**Drainage Memo
for
Lot 1, Seder Subdivision
(A Replat of Lot 7, Akers Acres Subdivision No. 1)
2725 Akers Drive
El Paso County, Colorado 80922**

Prepared by:
Kiowa
Engineering Corporation

Kiowa Project No. 24060
January 31, 2025

PCD File PPR255

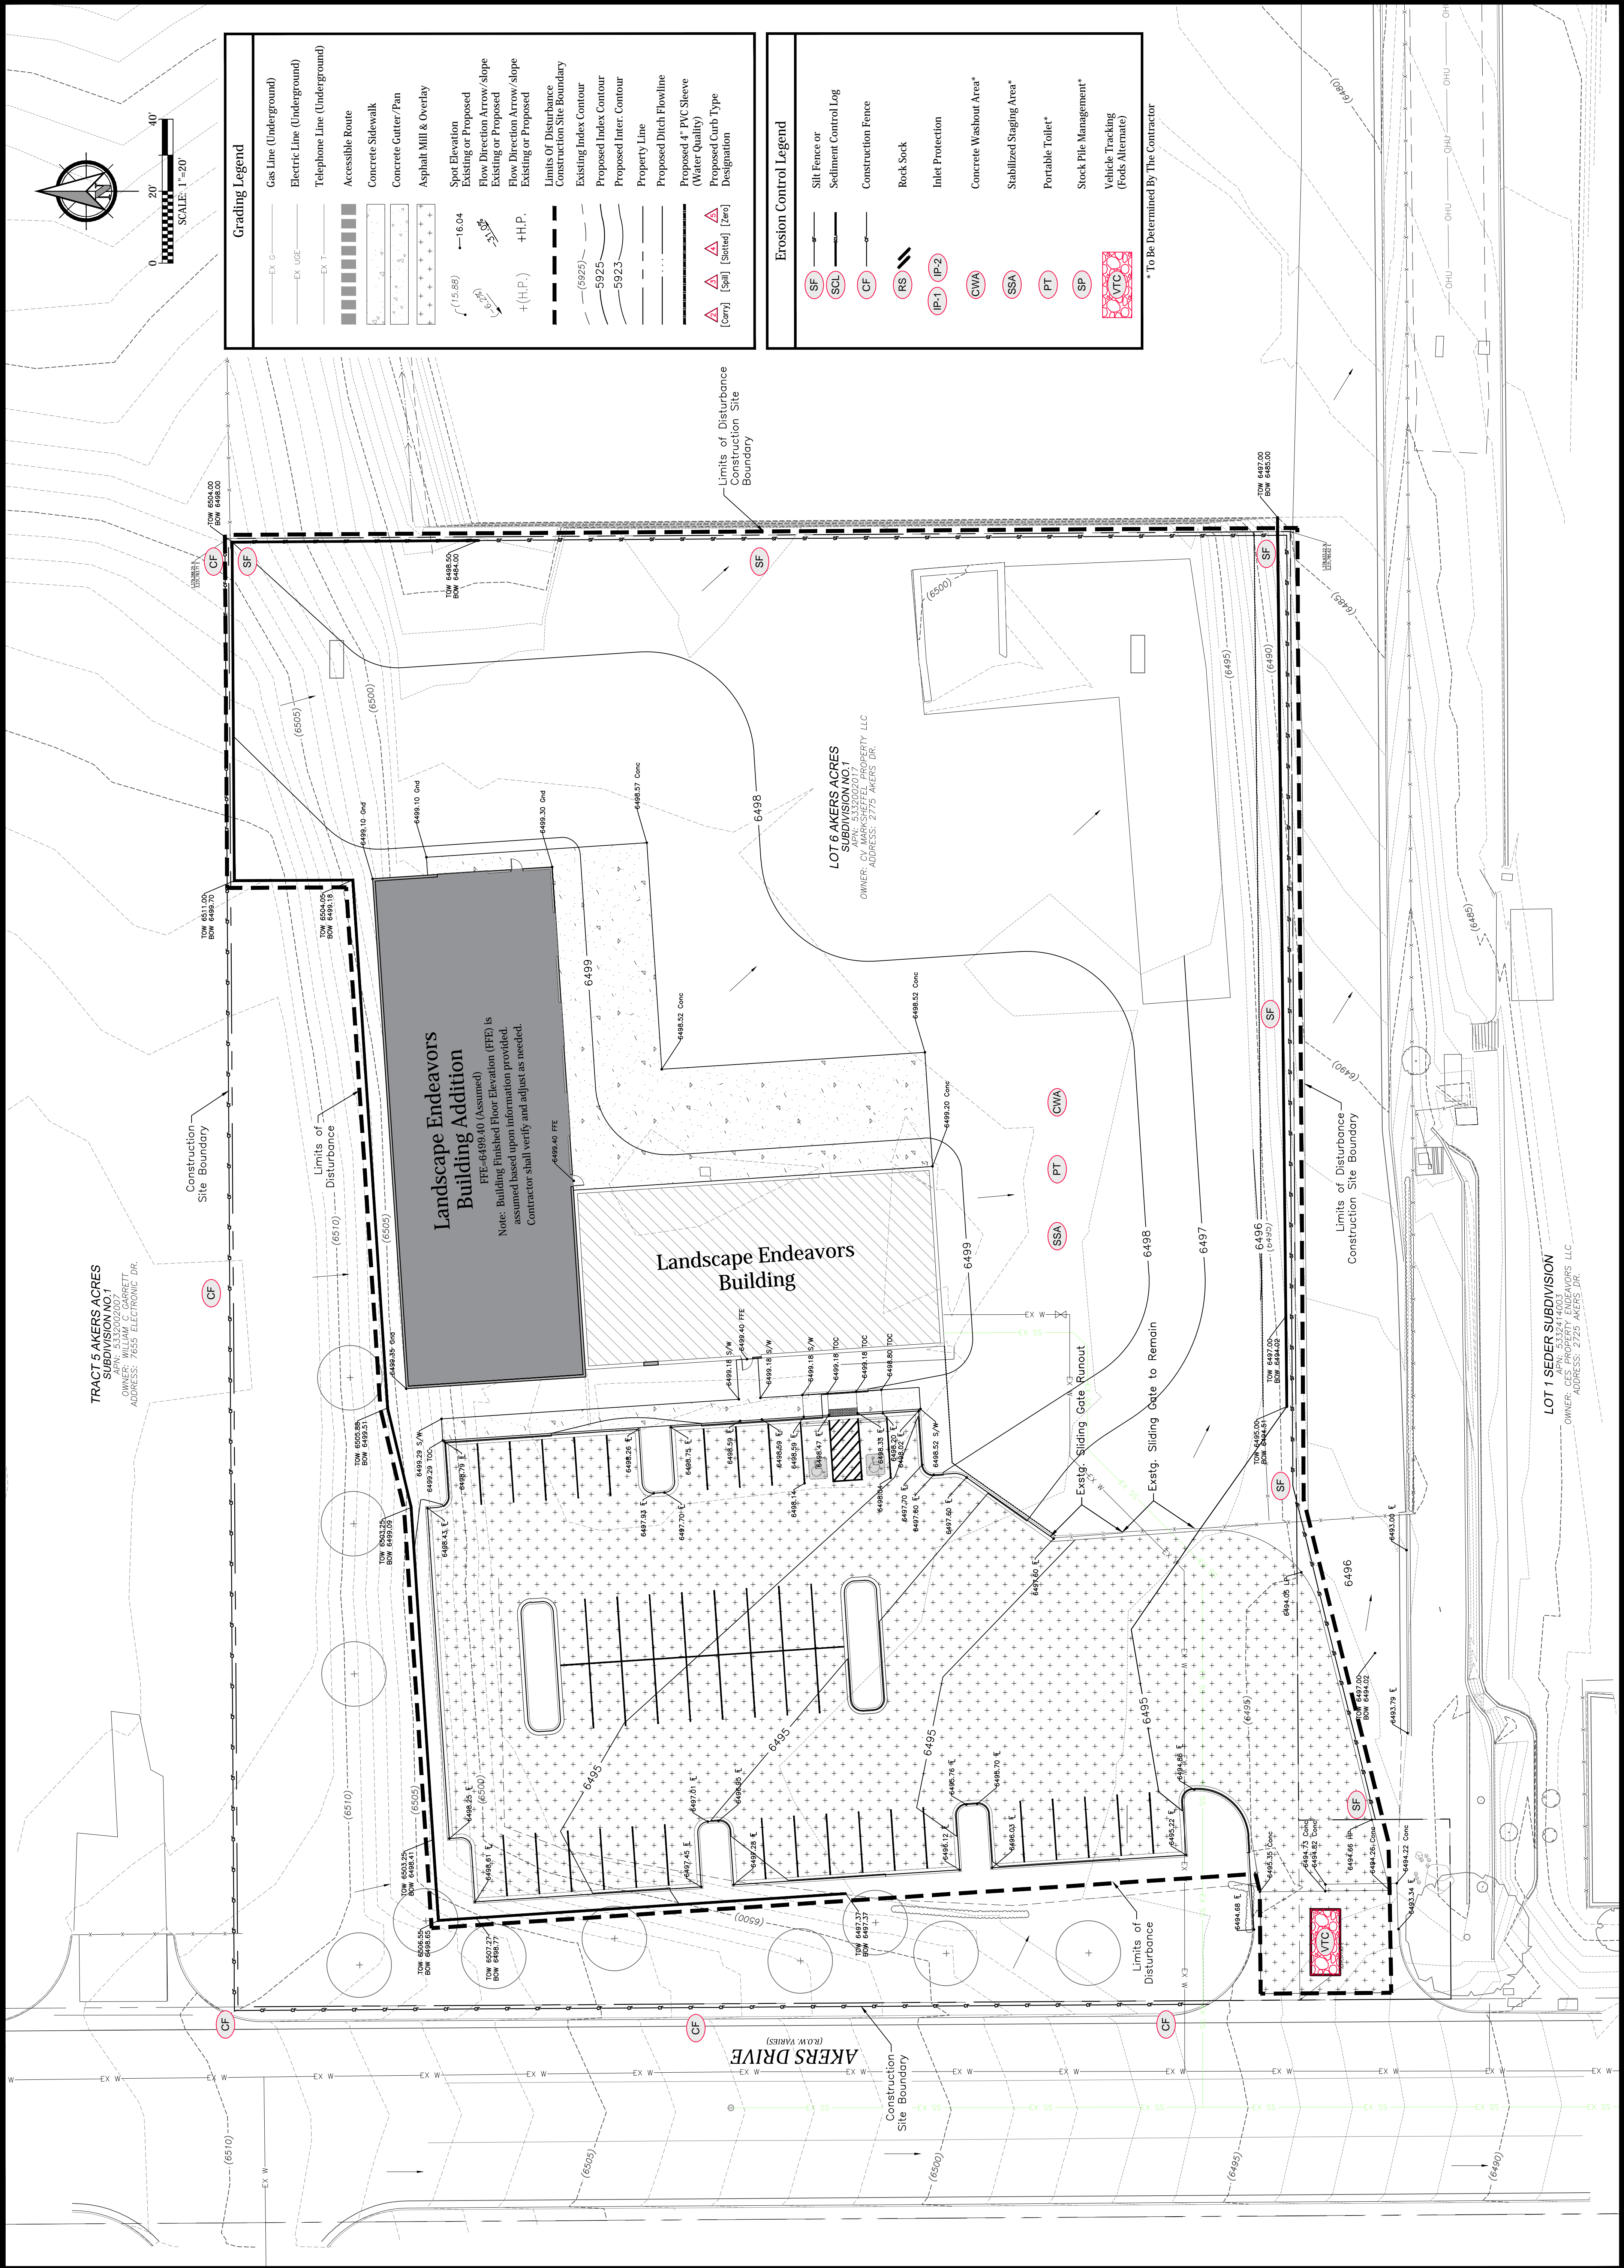
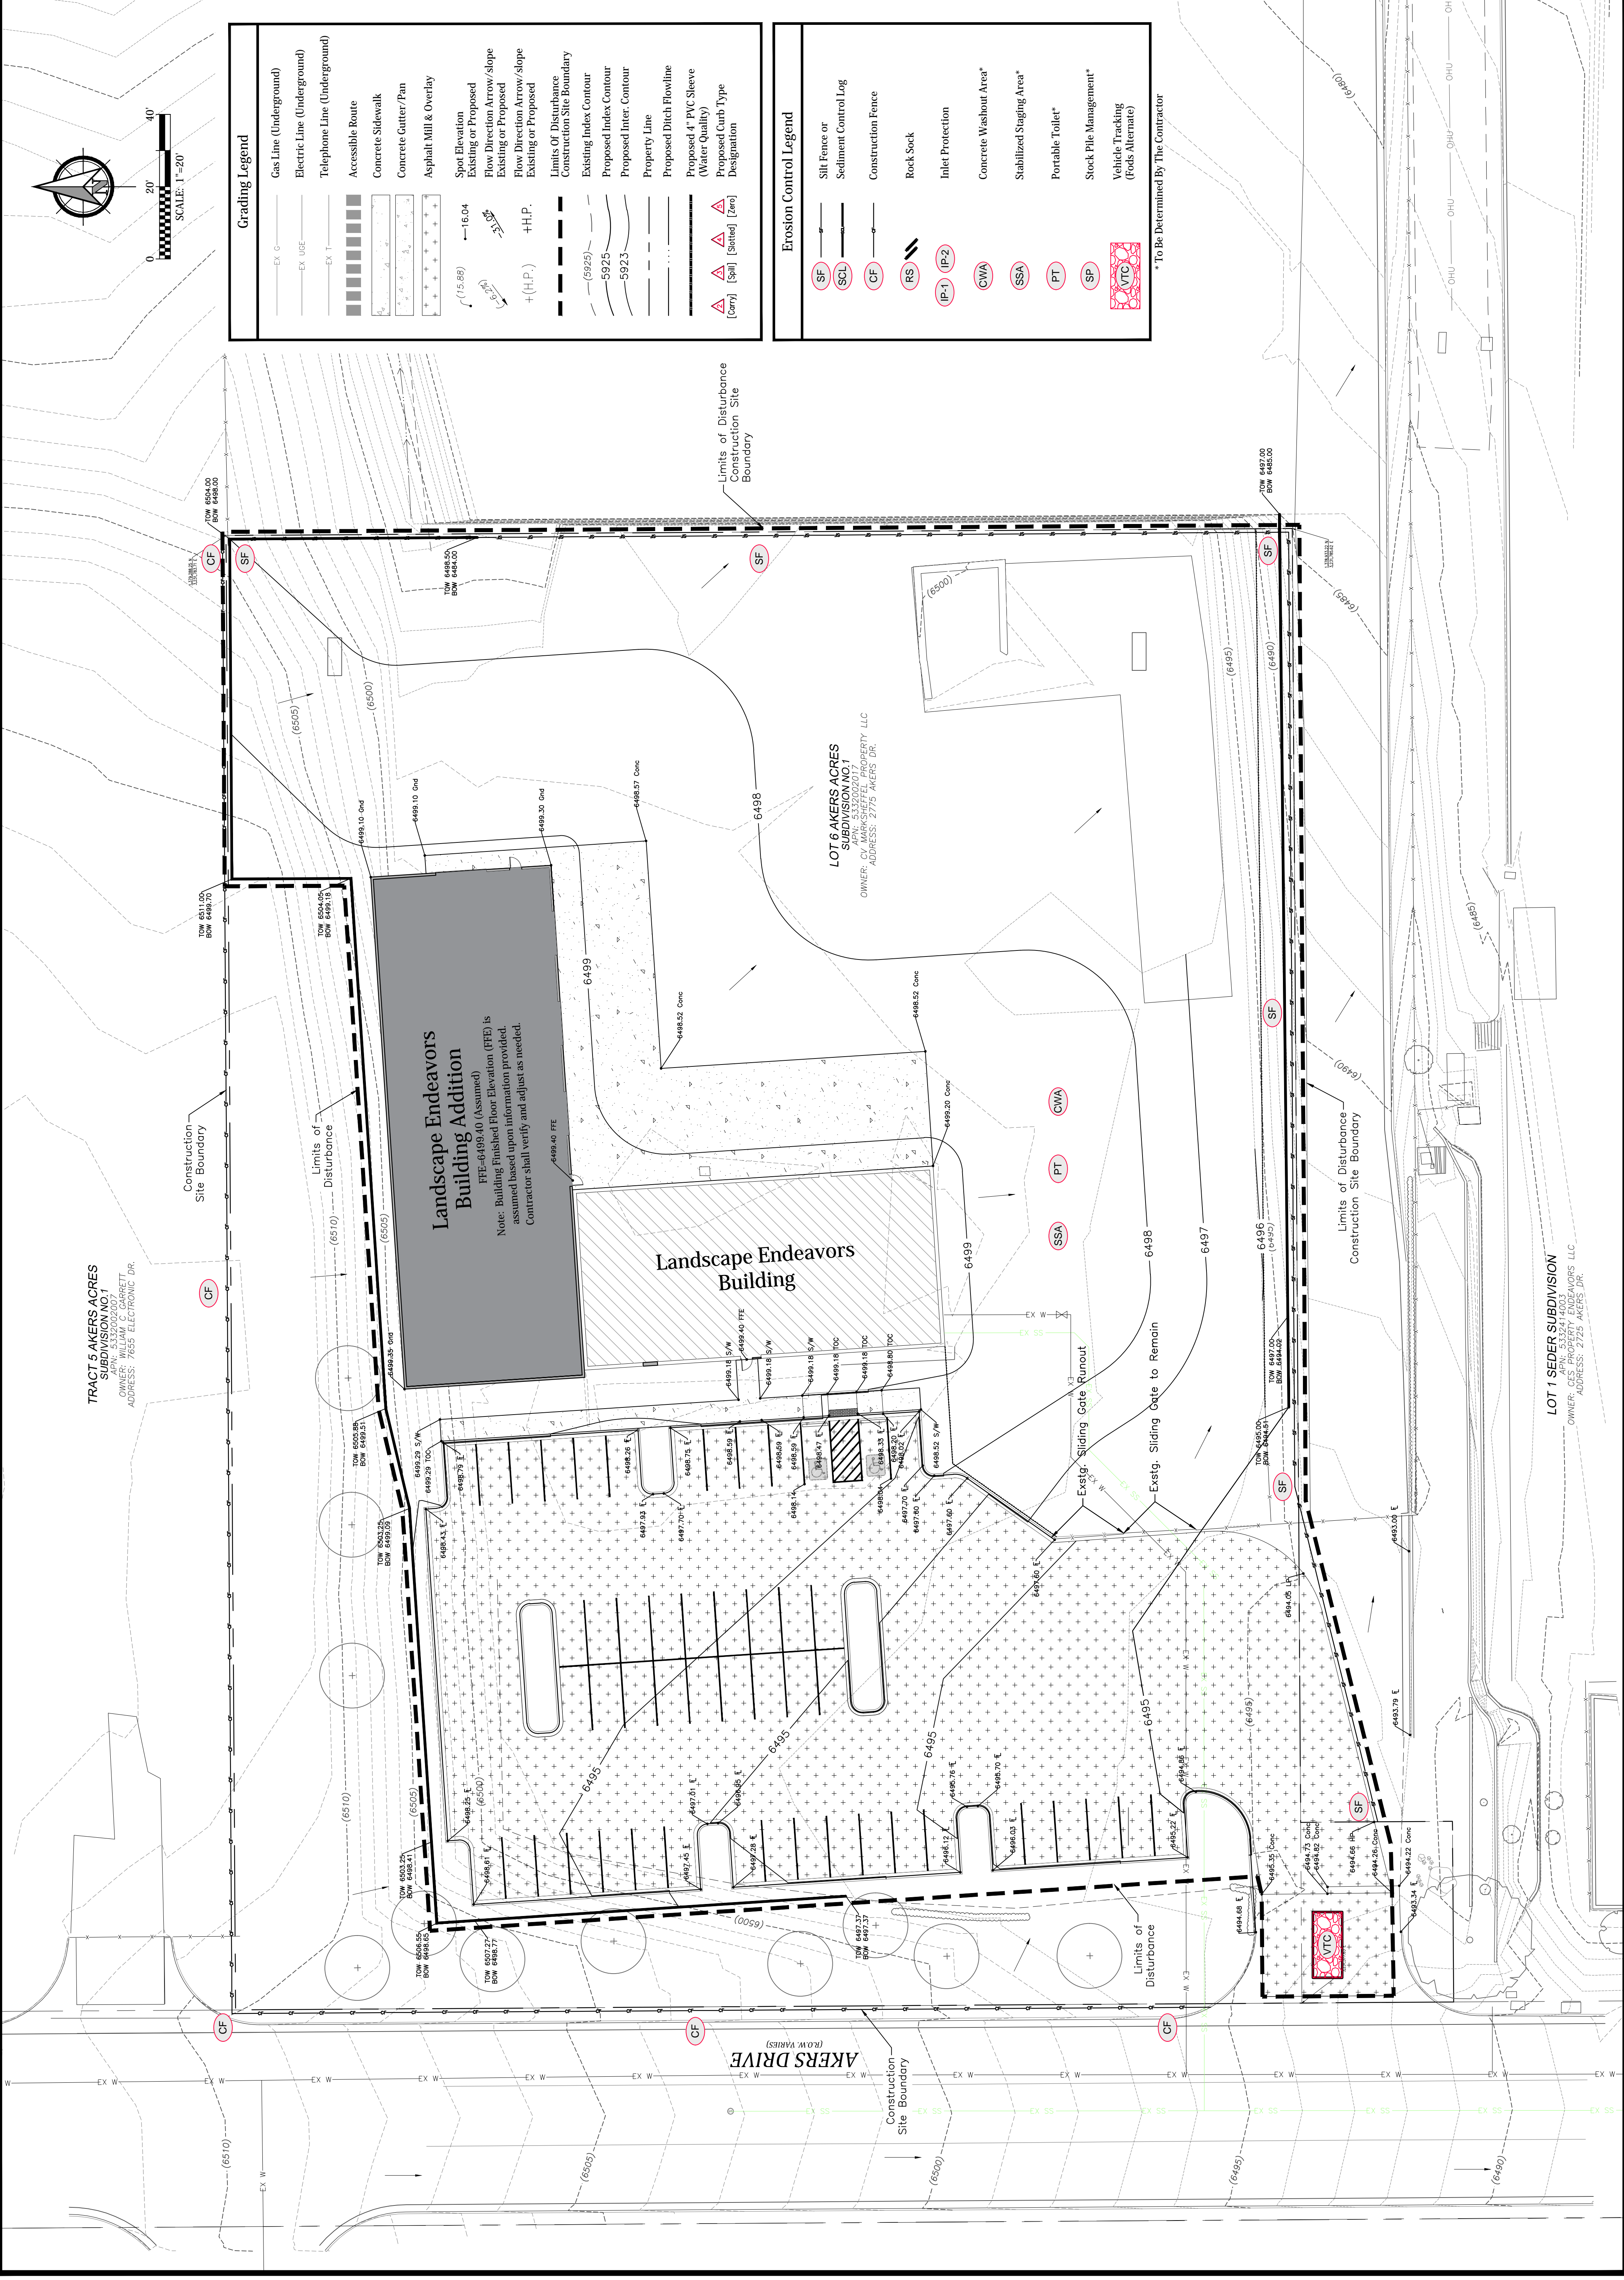
How is flow routing through or around the retaining wall to flow eastward

Address flow in this area. The GEC plan shows this area not being paved or stabilized. Site flows cannot discharge to the ROW

Currently the contours show the runoff leaving the site, how does the drainage reach the existing SFB?
